CITY OF PORTLAND
DEPARTMENT OF PLANNING & URBAN DEVELOPMENT

Inspection Violations

Owner/Manager CASALE CAROL A		Inspector Suzanne Hunt	Inspection Date 1/13/2010
Location 245 SPRING ST	CBL 056 G037001	Status Re-Inspect 14 Days	Inspection Type Complaint-Housing Inspection

SECOND FLOOR PLAN: 245 SPRING ST.
 1/10/18: ALARMS & EGRESS 7/10/17
 1/10/18: ALARMS & EGRESS 7/10/17

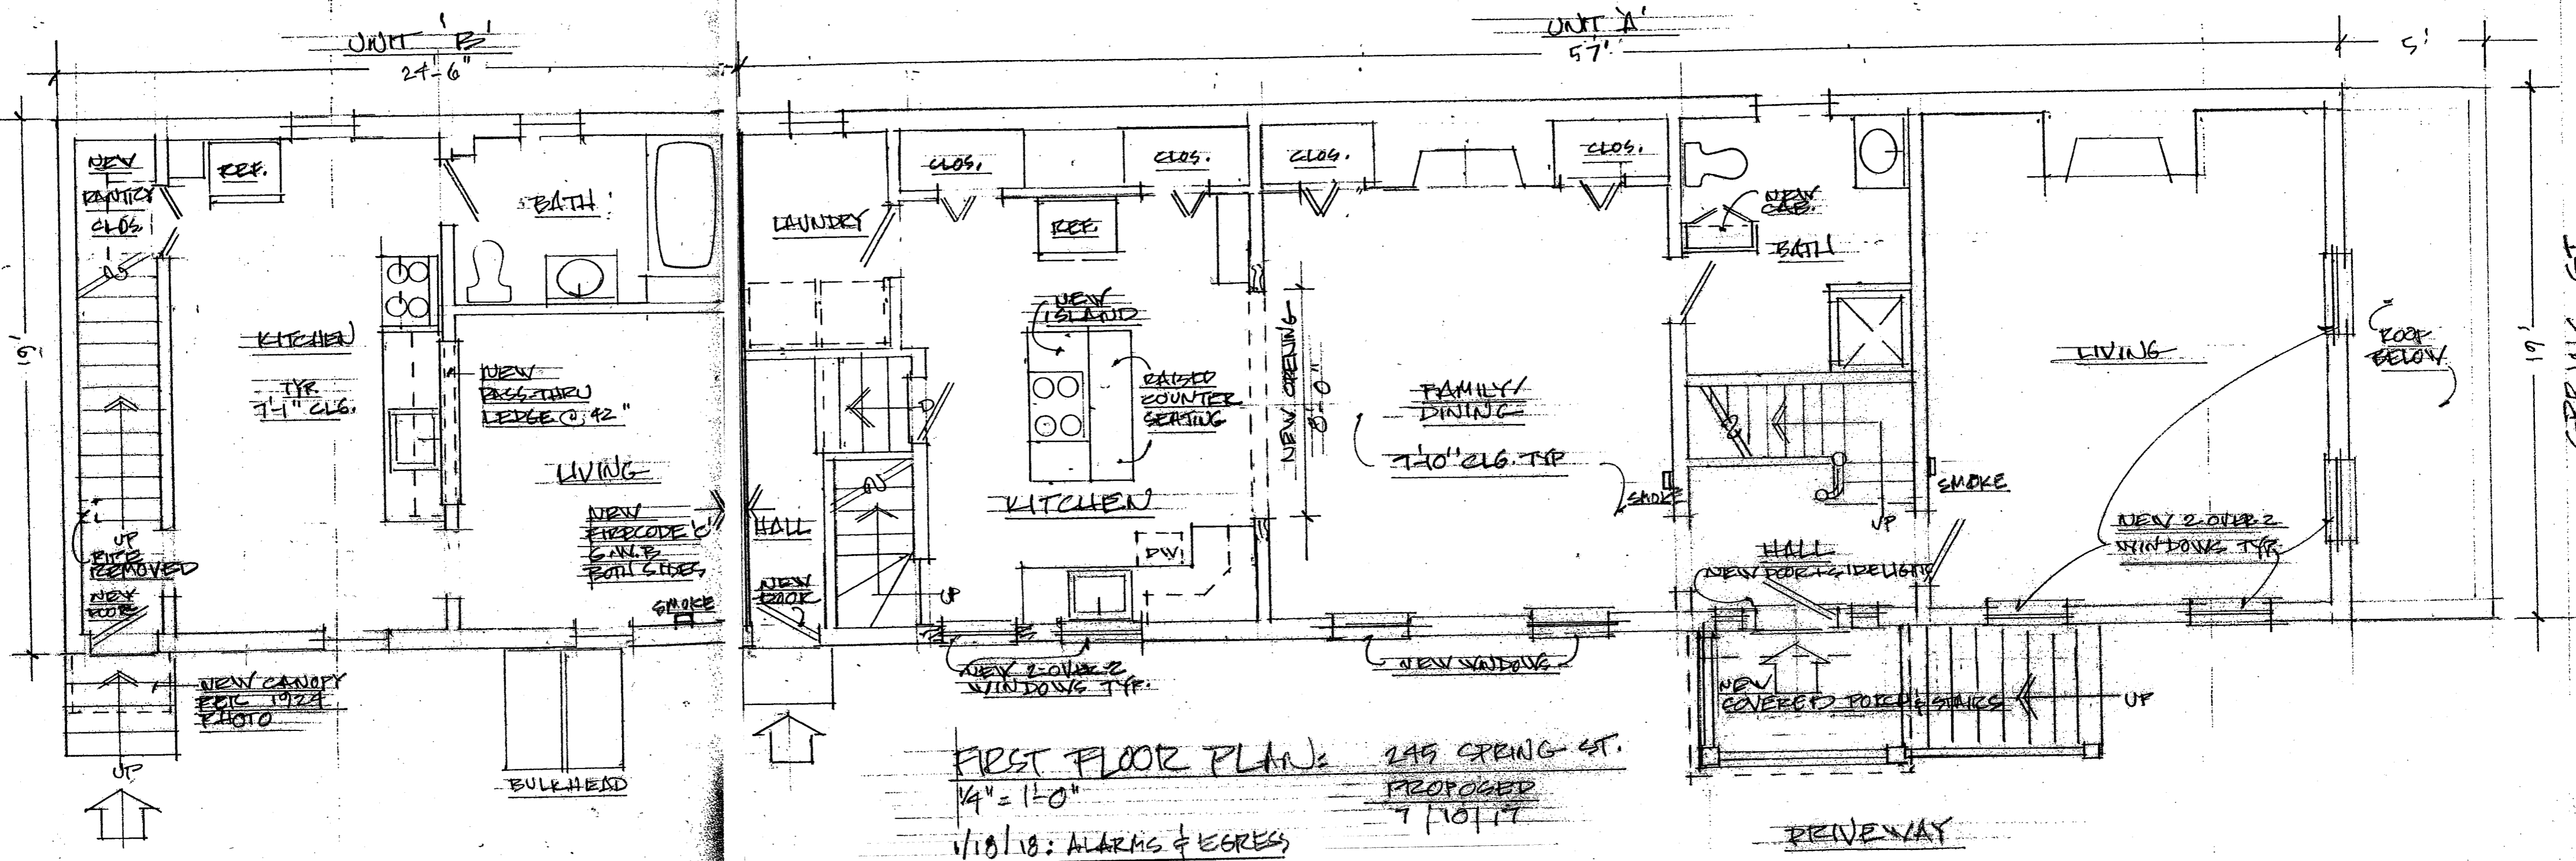
2) 6-116.(e)	Interior		2		
Violation: Fire Protection					
Notes: Hard wired smoke and carbon Monoxide Detector required floor 2 of unit 2 in hallway between bedrooms. A licensed electrician must install, a permit is required

Comments: Boiler in basement requires a permit to install. This requires a licensed tech. Basement area is full of debris, Debris must be removed a 5 foot clearance is required around fuel powered appliance (for example: Furnace , Water heater). Carbon Monoxide detectors required in vicinity of all bedrooms.(both units). The propane tank exterior building must be removed. This is not a listed use., Unit 2. . Unit 2 has no smoke detectors, a hardwired smoke detector must be installed on second floor in hall way between bedrooms.

BASEMENT FLOOR PLAN 249 SPRING ST.
 1/4" = 1'-0"
 1/18/18: ALARMS & EGRESS 1/10/17

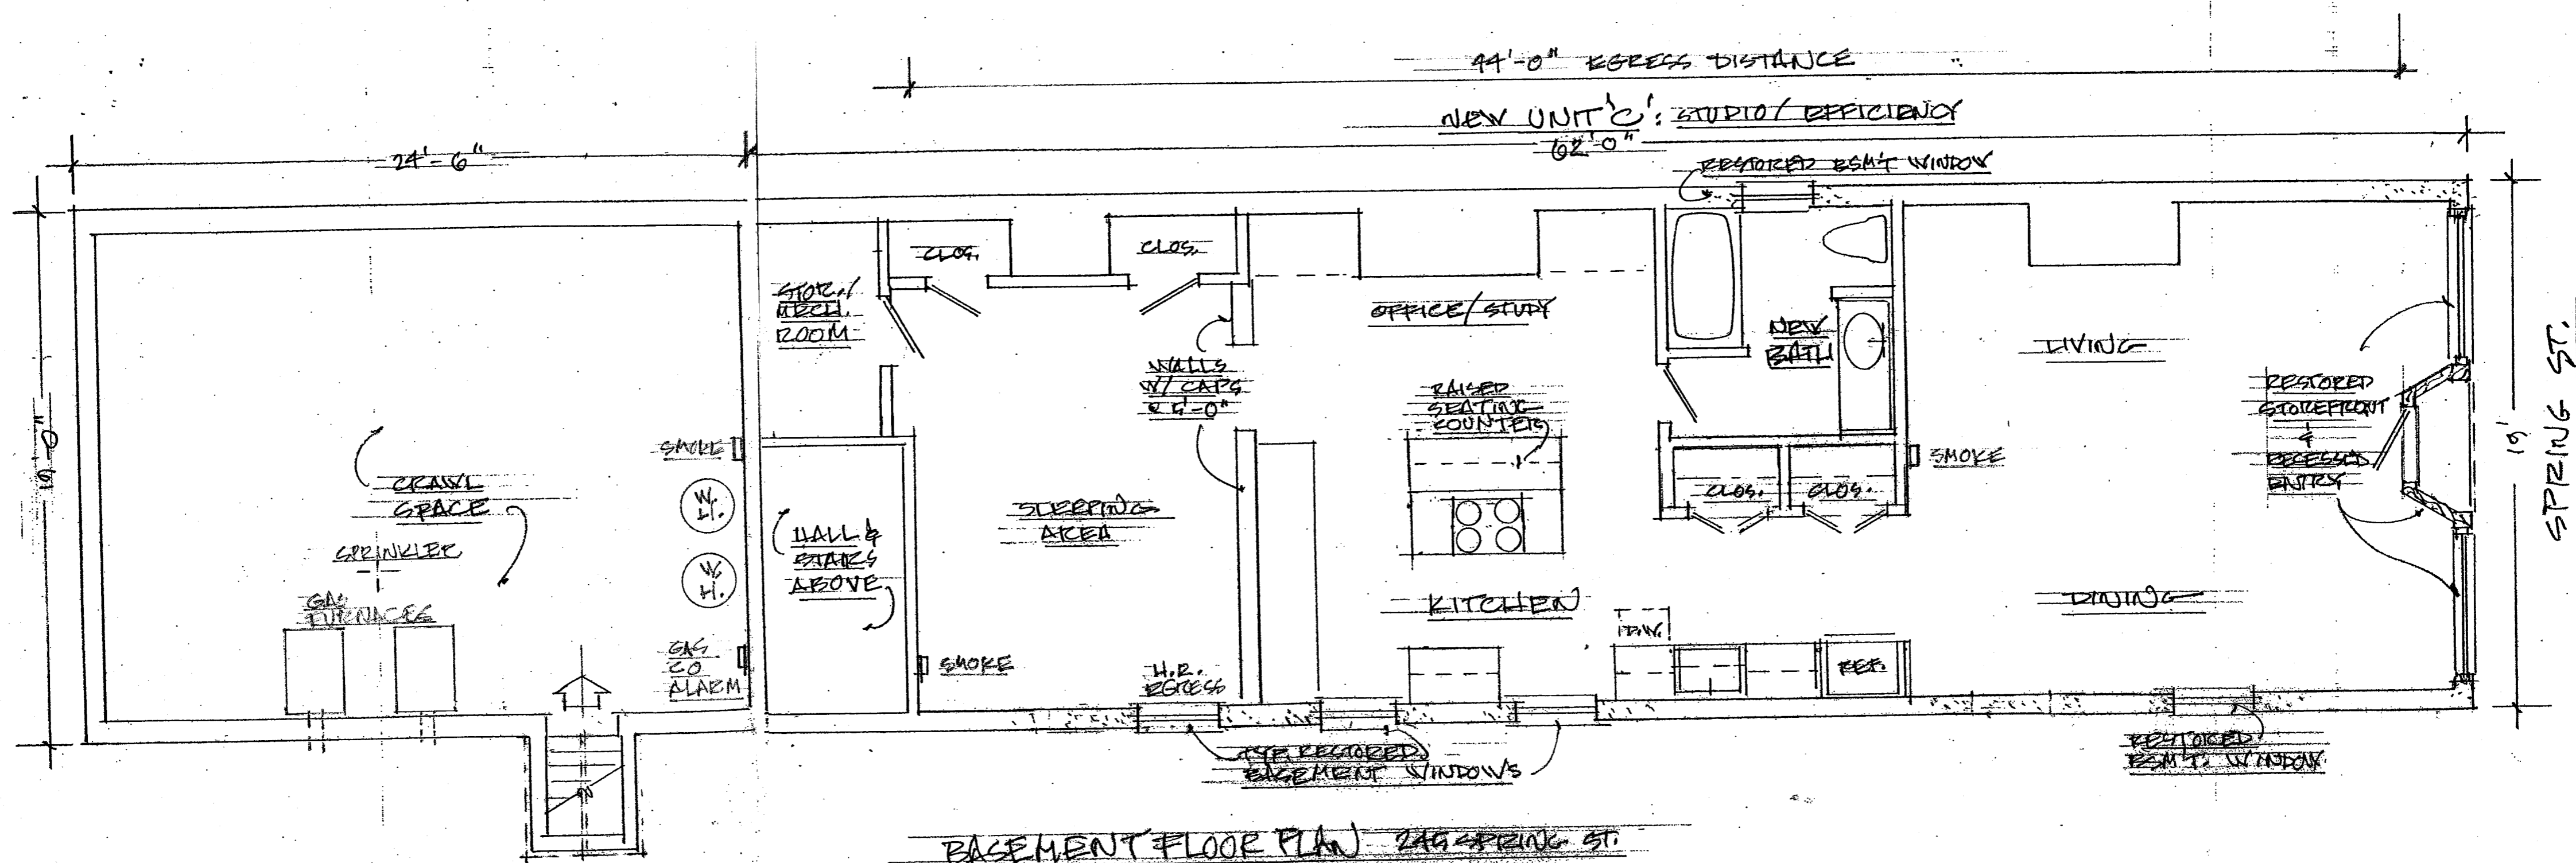
Code	Int/Ext	Floor	Unit No.	Area	Compliance Date
1) 105.1	Interior			Basement	
Violation: Building w/o Permit					
Notes: Boiler in basement requires a permit to install. This requires a licensed tech.

4) 110.26 (b)	Interior				
Violation: NEC 2005/NFPA 70					
Notes: The basement areas must be cleared of debris and excessive storage a five foot clearance is required around fuel powered appliances, ie the gas water heater and possible future boiler.

7) 6-116.(e)				Basement	
Violation: Fire Protection					
Notes: Basement is required to have a hard wired smoke detector.
